Re: Planning Application 19/0916

**Address: Camping Barn at Clark House Farm Fish House Lane Chipping
PR3 2GQ**

**Description: Change of use from holiday accommodation to residential
dwelling with minor alterations.**

Amend - A. W. Crank Removed

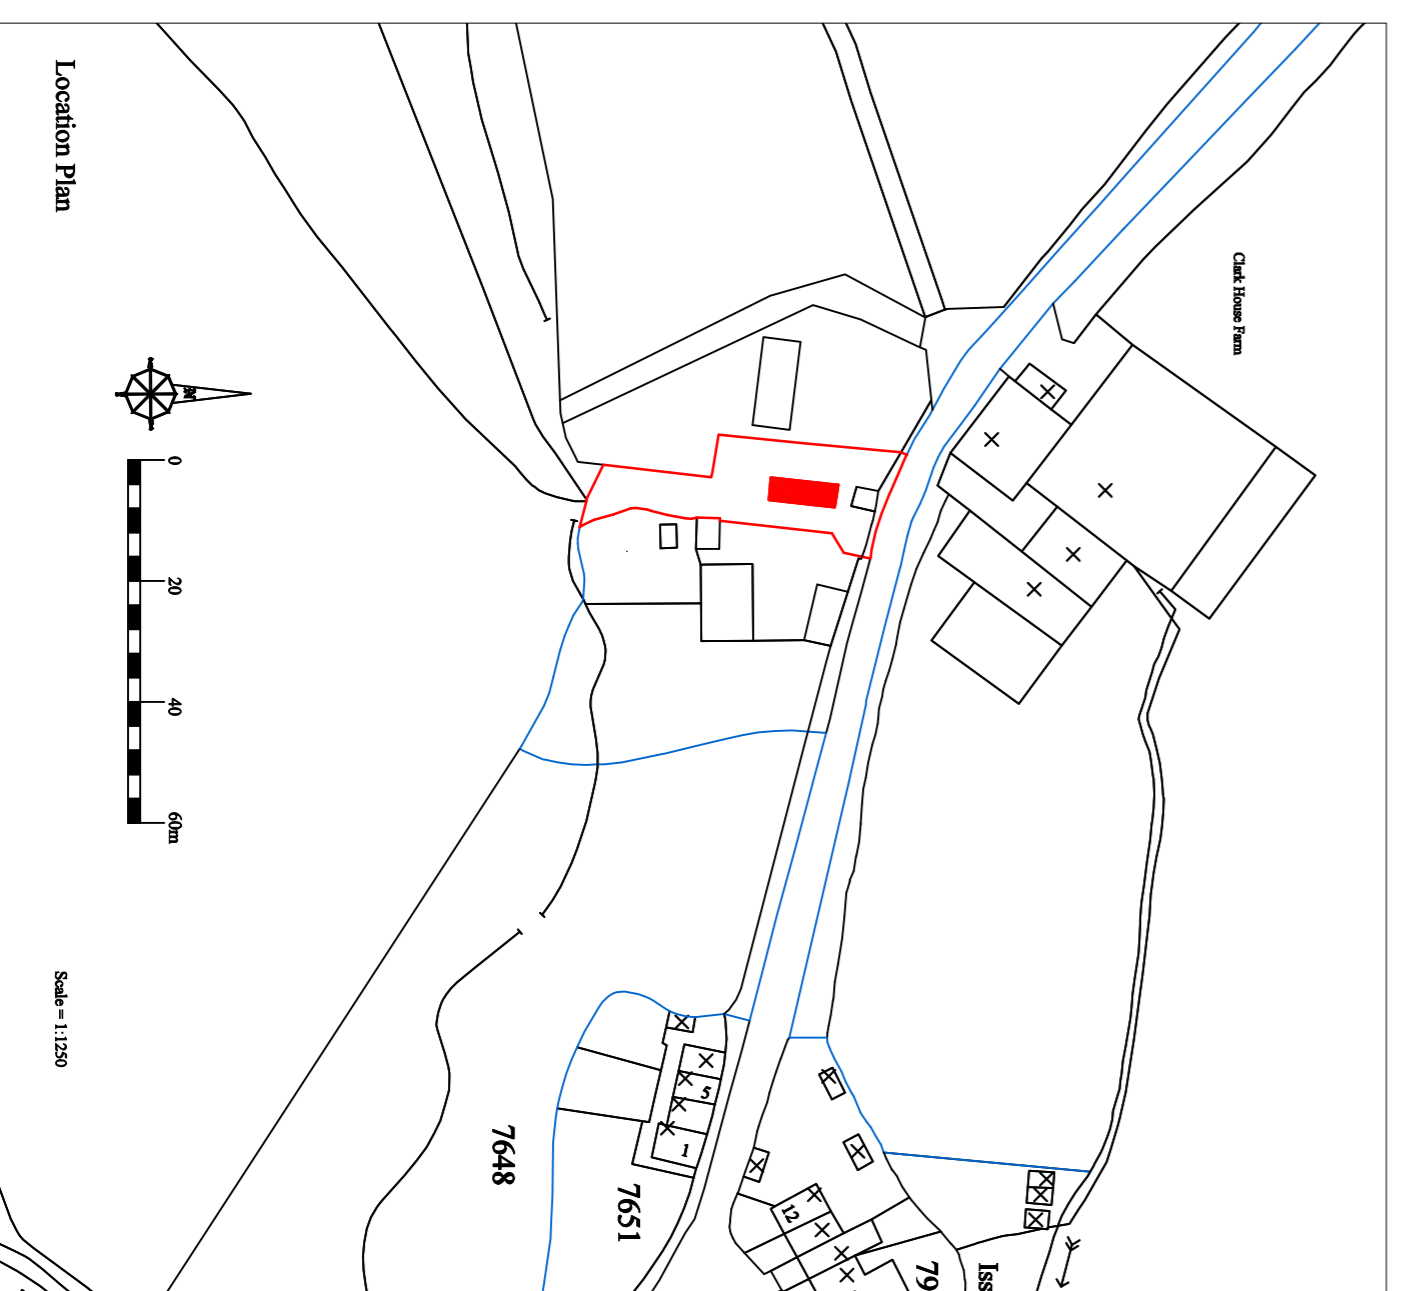
Previous concerns regarding the facility to enable vehicles to enter and exit the drives in a forward gear have been addressed
